THE  STAR

MODIFICATION 13
ACCESSIBILITY
DESIGN REVIEW

The following final report (dated 30th January 2018) is a review of the Development Application documentation and provides a summary of the compliance strategy of the proposed works highlighting the key principles of accessibility as well as the technical requirements of a building to ensure the public, staff and visitors, have equitable and dignified use.

The report is prepared in relation to “Modification 13” at The Star Entertainment Group in Sydney. The proposed works in relation to Accessibility considerations include:

title
General Arrangement Plans
Level 01 Floor Plan

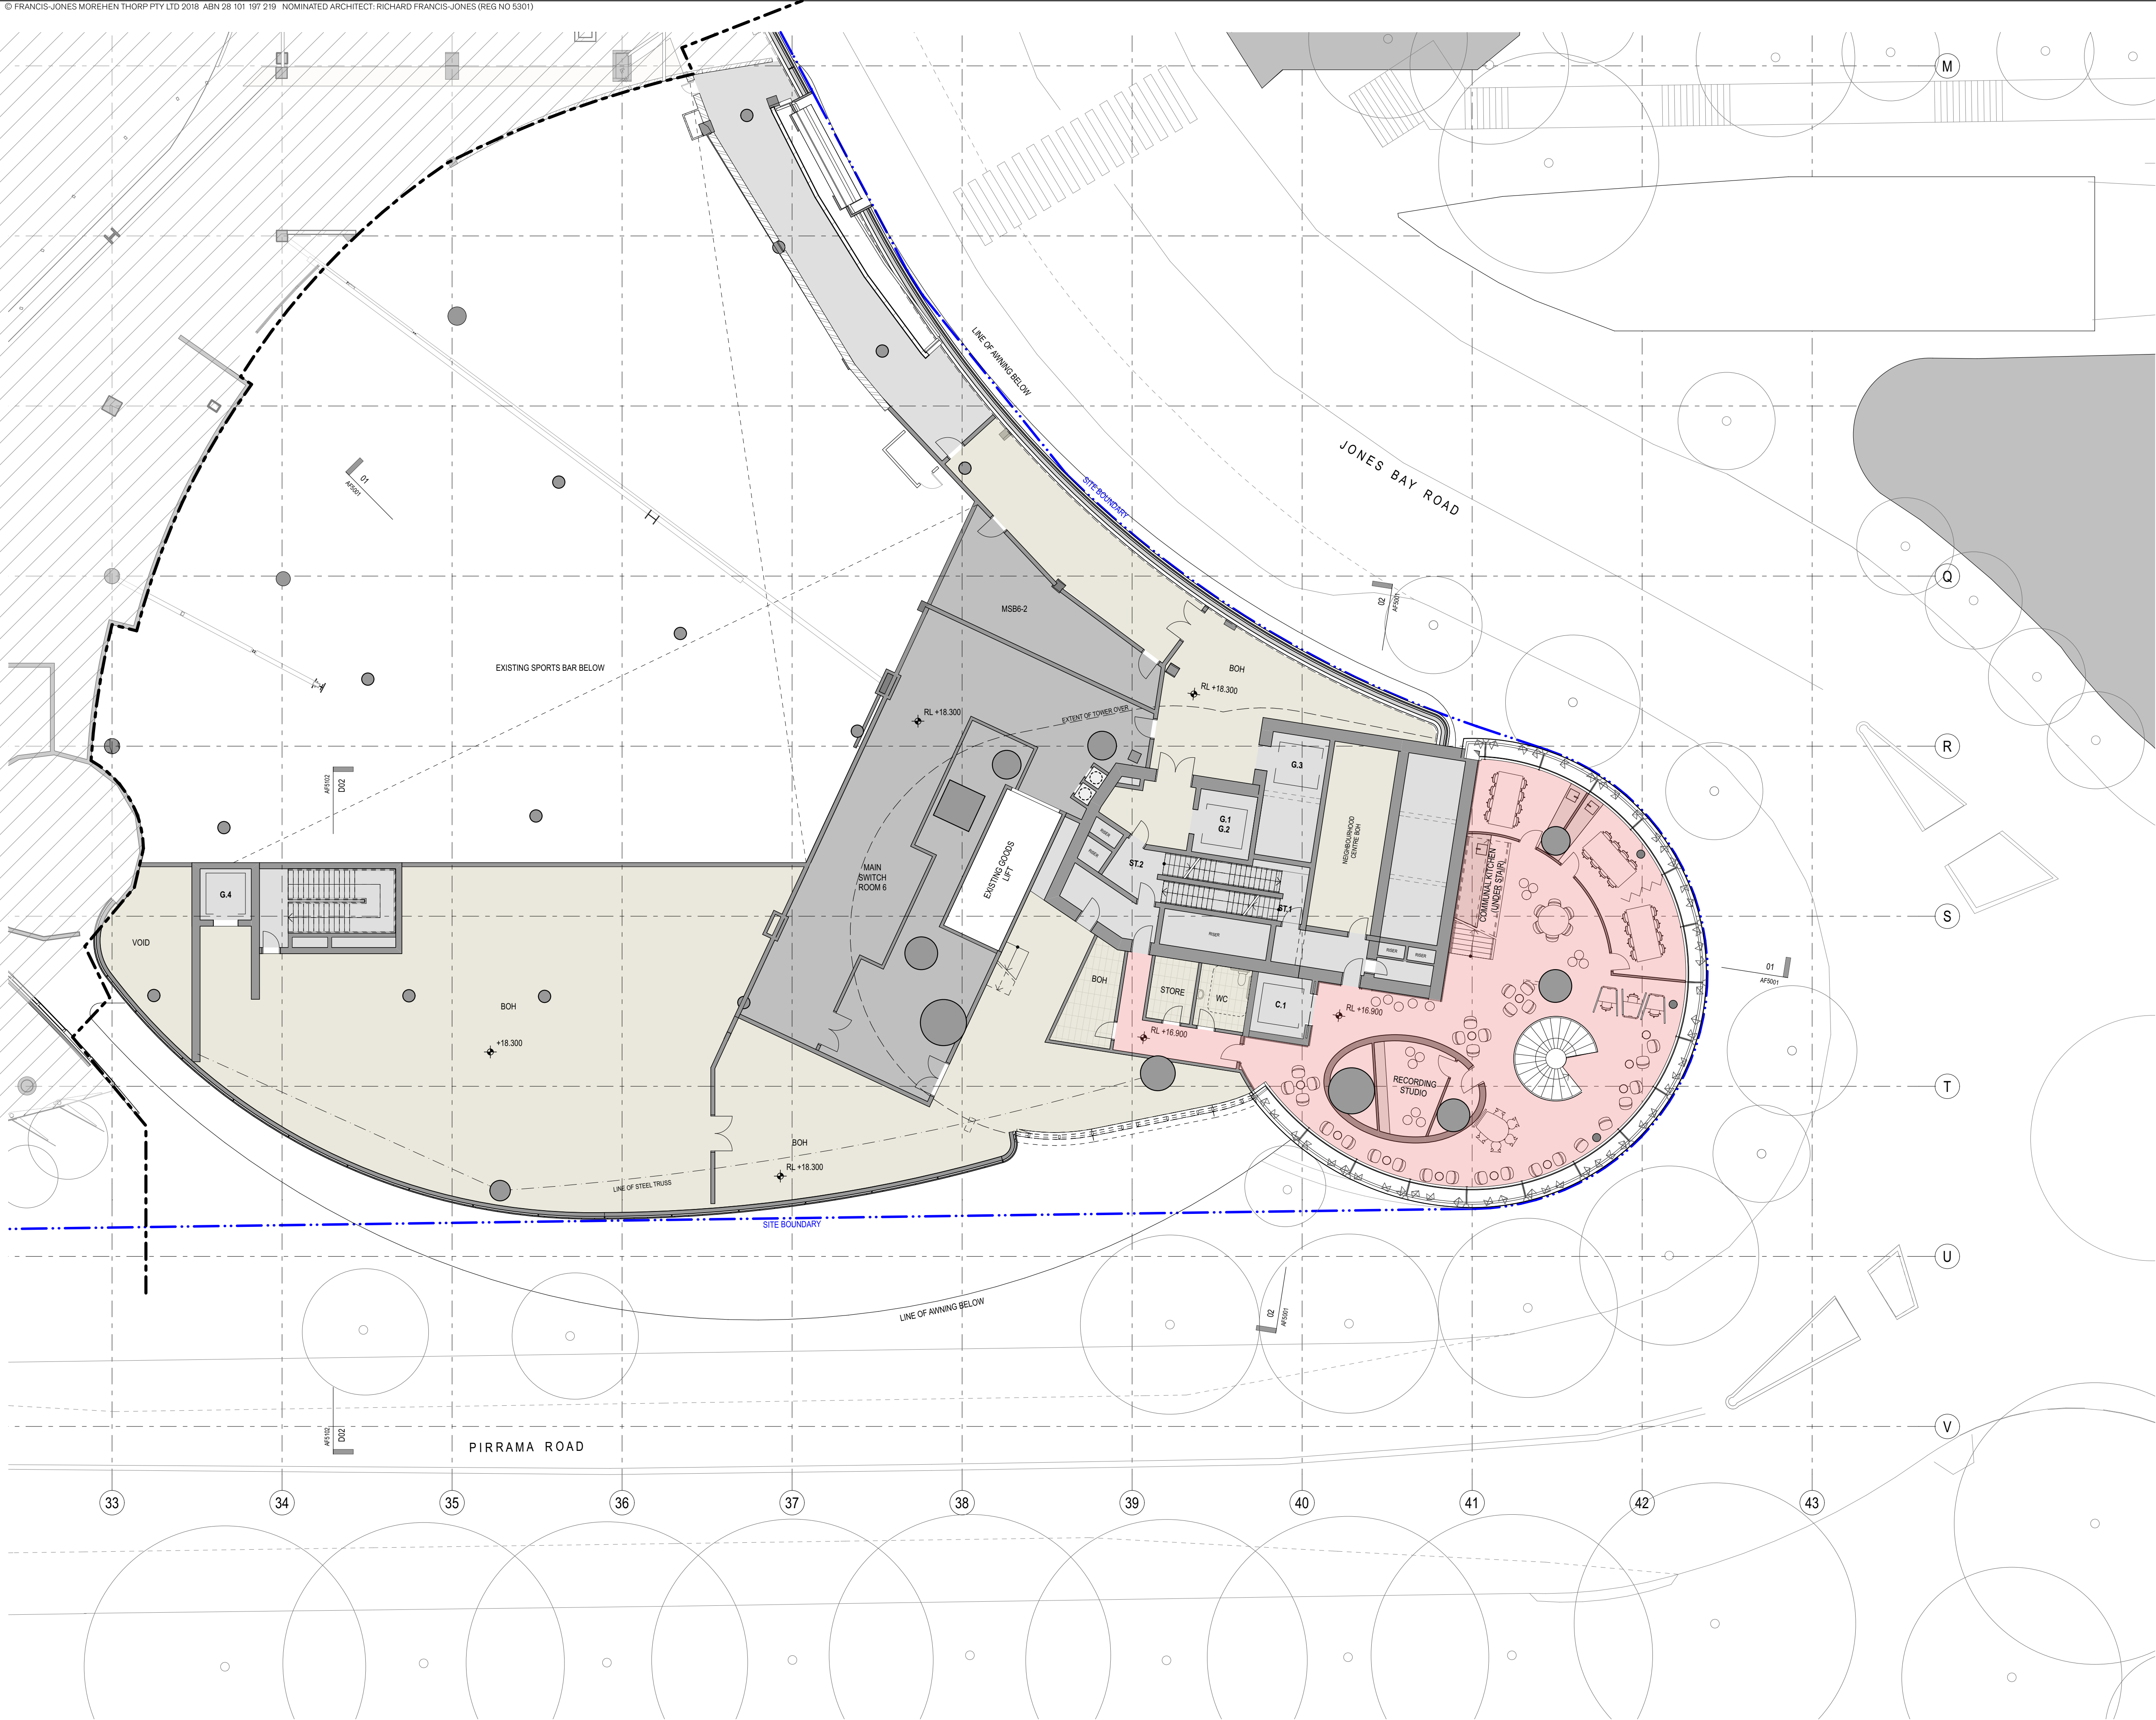
Whilst the BCA permits provision of a spiral staircase, it does not meet the enhanced design provisions of AS1428.2 and as such poses a design risk for people of varying disabilities. Ensure stair 'going' dimension is maintained at its greatest in order to mitigate the pinchpoint of narrow goings to the inner circumference of the stair – coupled with provision of compliant nosings and stair handrails.

The Accessible WC's provided as part of the Neighbourhood Centre shall alternate the handed design of the WC/ grabrails at each level that they are provided.

As above, access to & the use of the Data Recovery Centre, Residential Waste store and BOH areas are deemed exempt from the requirement to be accessible, as permitted under Clause D3.4 of the BCA
